Harnett County Government Complex
307 Cornelius Harnett Boulevard
Lillington, NC 27546

February 18, 2005

Re: Status of Improvement Permit Application #⁵4-5-11315
Lot 73 Woodshire

Revised x 2

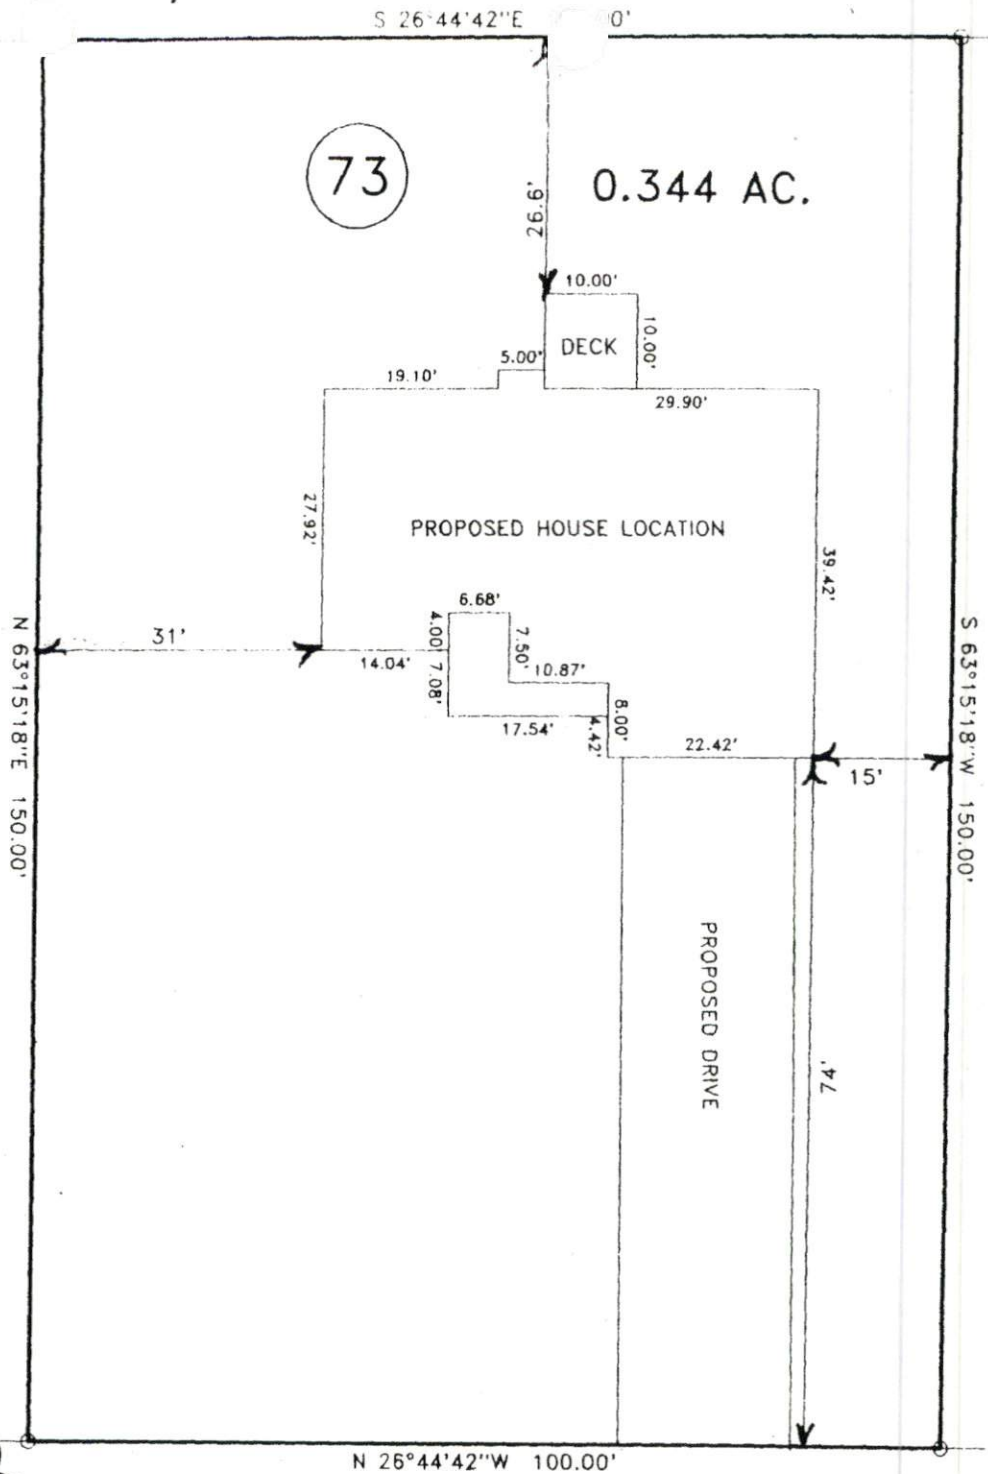
- 1. Property lines/corners not marked or labeled
- 2. House corners not marked or labeled
- 3. Directions not clear to property
- 4. Property needs brush or vegetation removed
- 5. Backhoe pits required
- 6. Other **Due to lot size, soil condition etc., you will need to change this house from 4 bedrooms to 3. Please submit changes to Central Permitting so that the permit can be issued.**

*HH
Called on
#1/11/05 - Lynn
to Randle - chg. from
4 to 3 bdrm - Resubmit
per JW -*
